**RE: Oakland Ridge Subdivision
Grading Plan
Stamp Date: 7/17/17
Hydrology File: C18D085**

Based upon the information provided in your re-submittal received 7/17/2017, the Grading Plan is approved for Preliminary Plat action by the DRB and Grading Permit with the following comments:

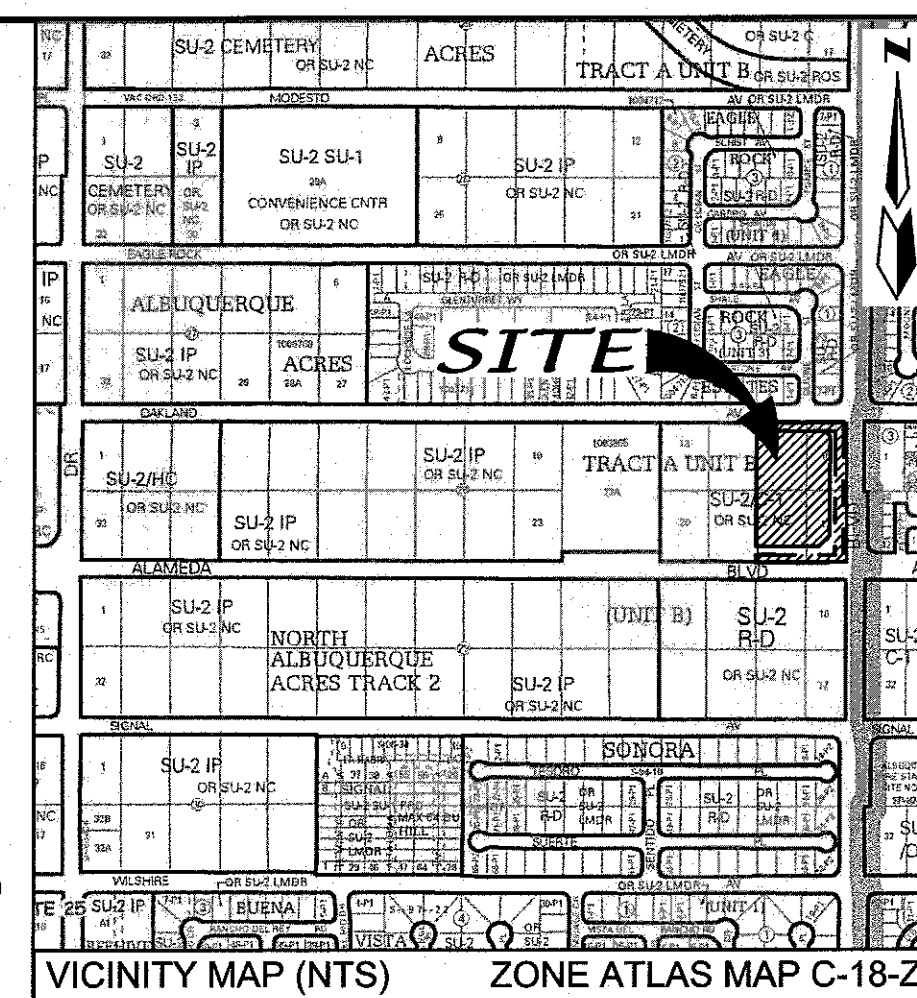
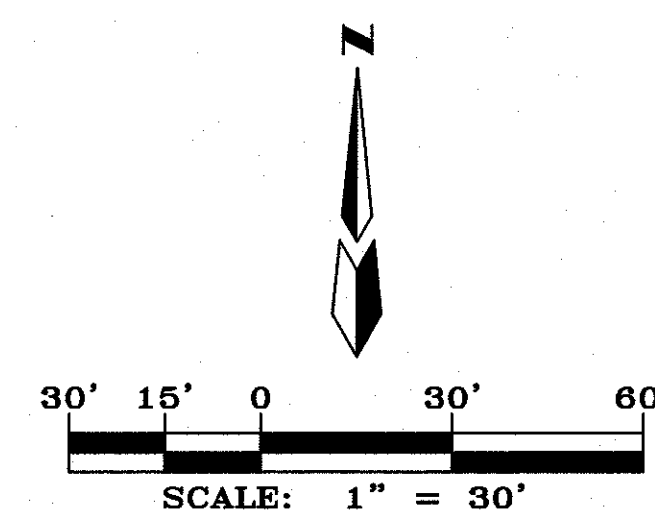
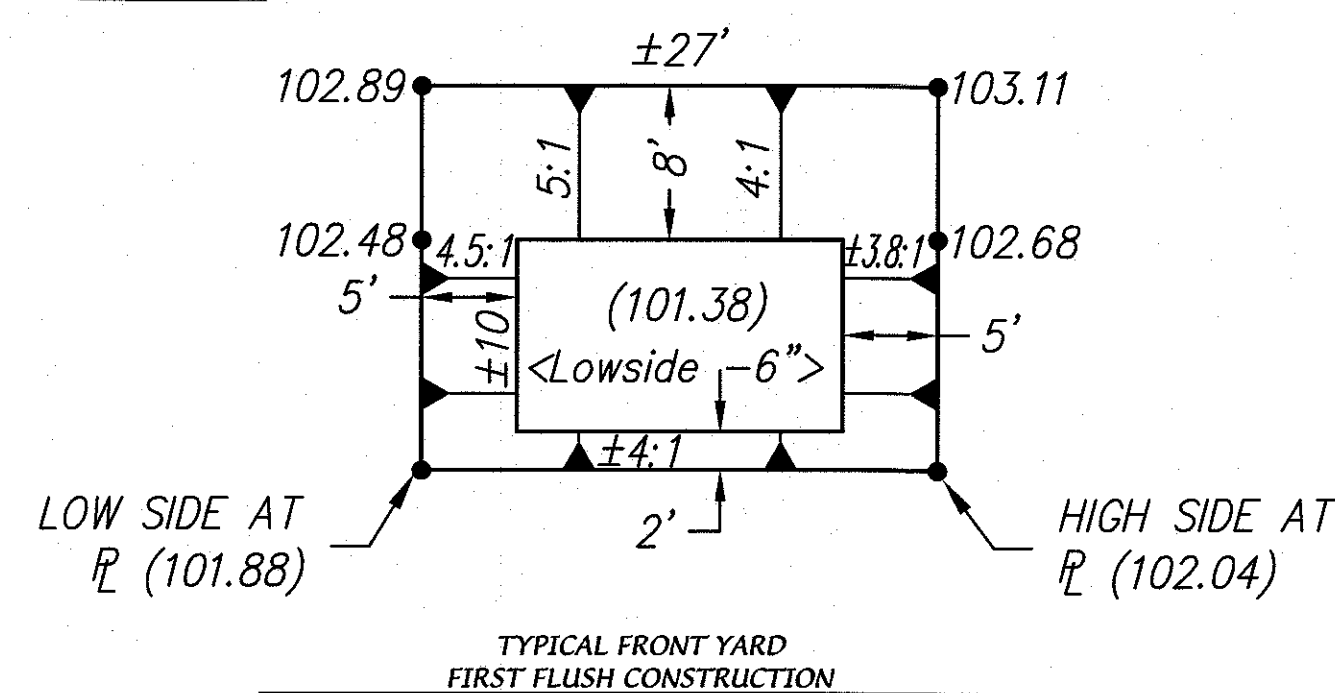
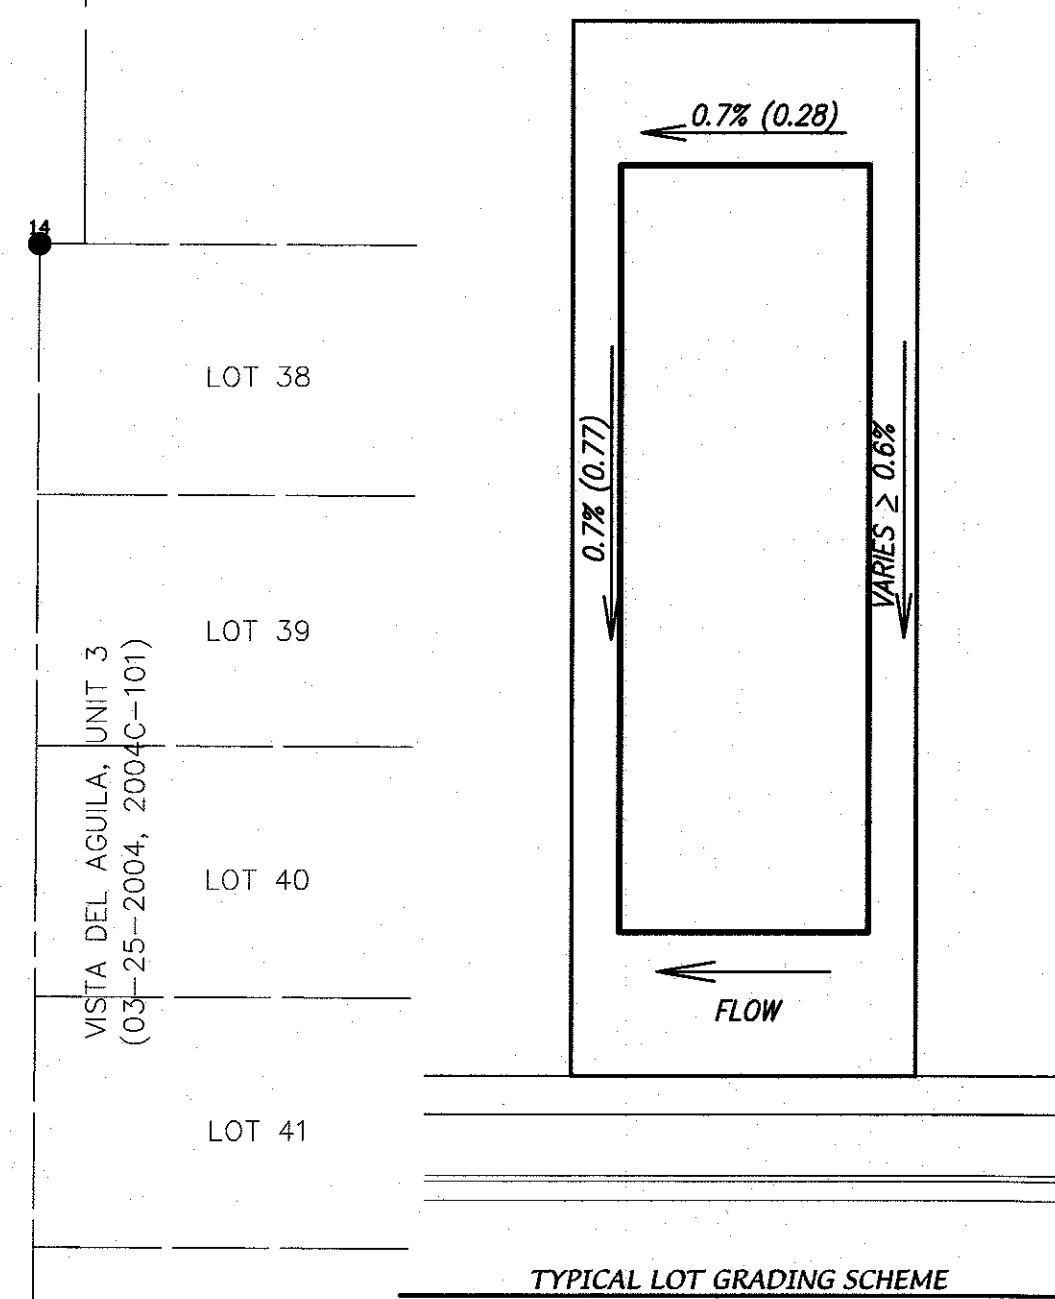
- On the typical perimeter wall Detail, change the existing sidewalk (Alameda) to existing sidewalk (Louisiana).
